### **Paling Yards Wind Farm – Environmental Impact Statement (SSD-29064077)**

Thank you for your e-mail dated 9 October 2023 to the Biodiversity, Conservation and Science Directorate (BCS) of the Department of Planning and Environment (DPE) seeking advice on the Environmental Impact Statement (EIS) and Biodiversity Development Assessment Report (BDAR) for the Paling Yards Wind Farm. Please note that this advice represents the combined views of BCS and the NSW National Parks and Wildlife Service (NPWS).

**Sarah Carr**  
**Director North West**  
**Biodiversity, Conservation and Science Directorate**

21 November 2023

Figure 3. Paling Yards Wind Farm Site Layout (Source: Tract 2022)

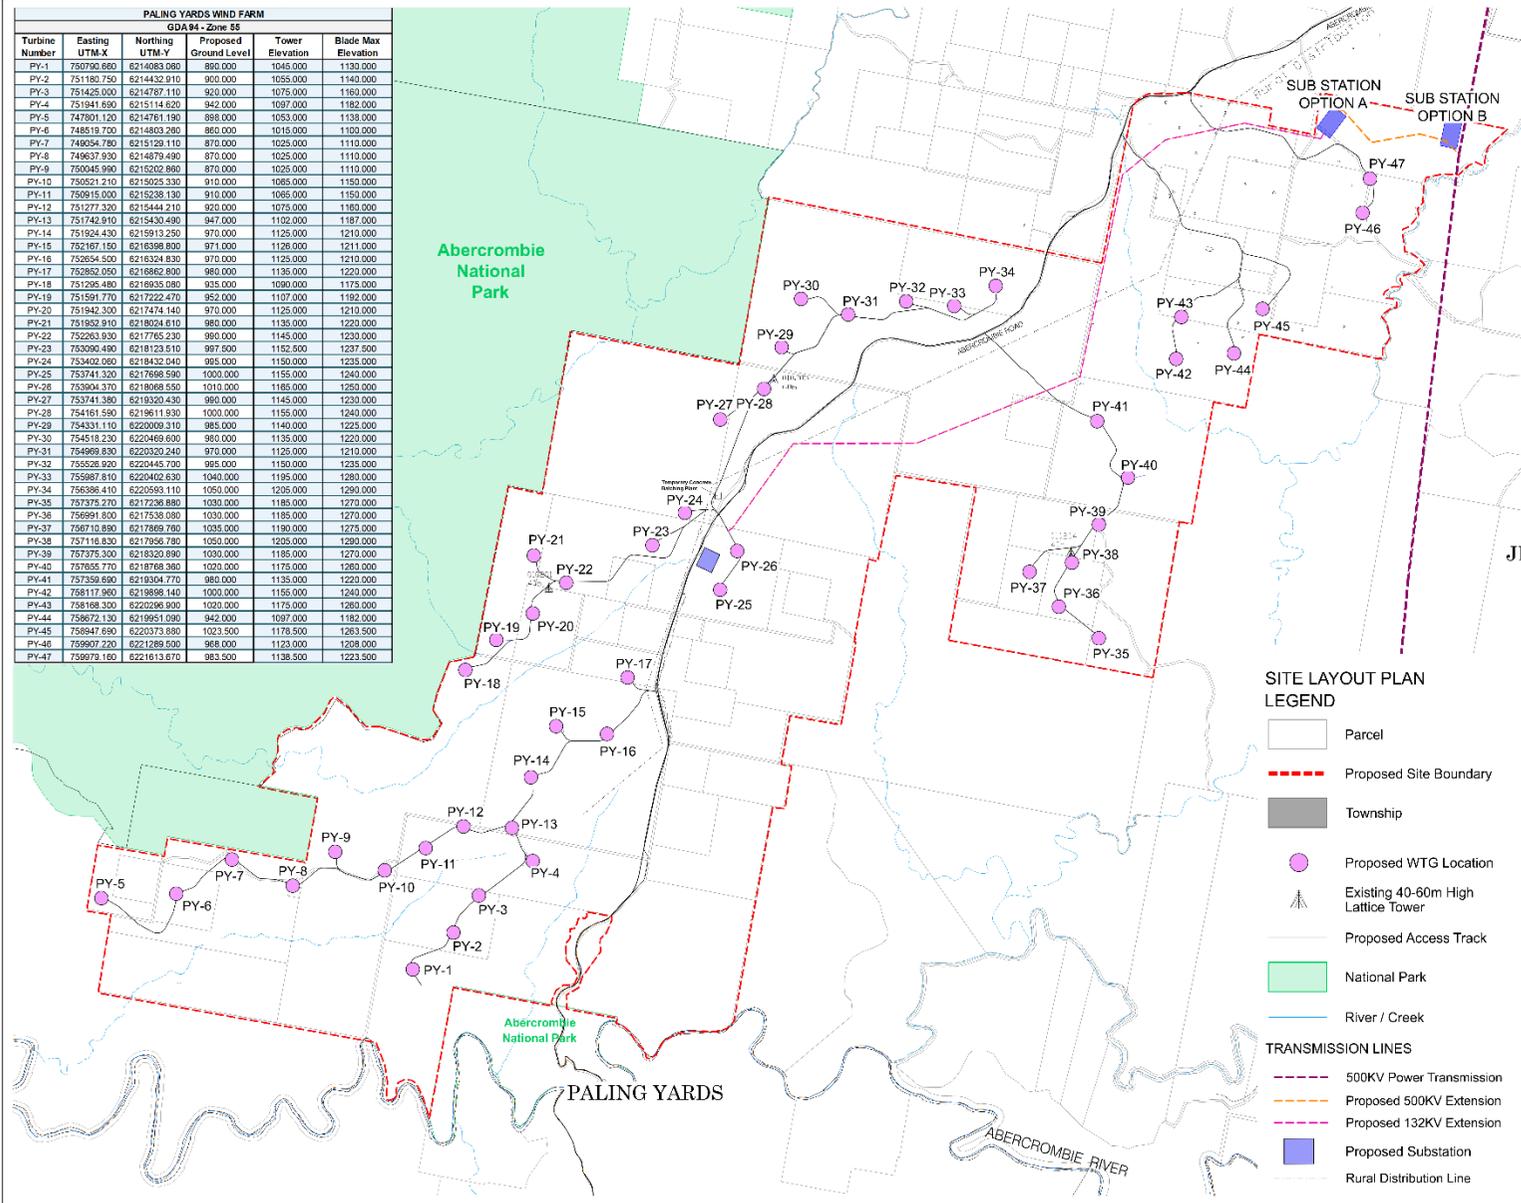
The indicative site layout provided in Figure 12 of the EIS is also inconsistent with the project layout displayed in Figure 1.1 of the BDAR. One sub-station has not been assessed in the BDAR and associated spatial package (Figure 1). If the sub-station has been excised from the footprint, the EIS should be revised to show the current development footprint.

Figure 1 – Figure 12 in the EIS shows two sub-stations in the north-east corner (highlighted in blue) while Figure 1.1 of the BDAR only includes one sub-station (highlighted in yellow).

- 2.1 Clarify whether all components of the development that will impact on biodiversity values, including ancillary and temporary facilities, have been included in the development corridor and subsequent biodiversity credit calculations.
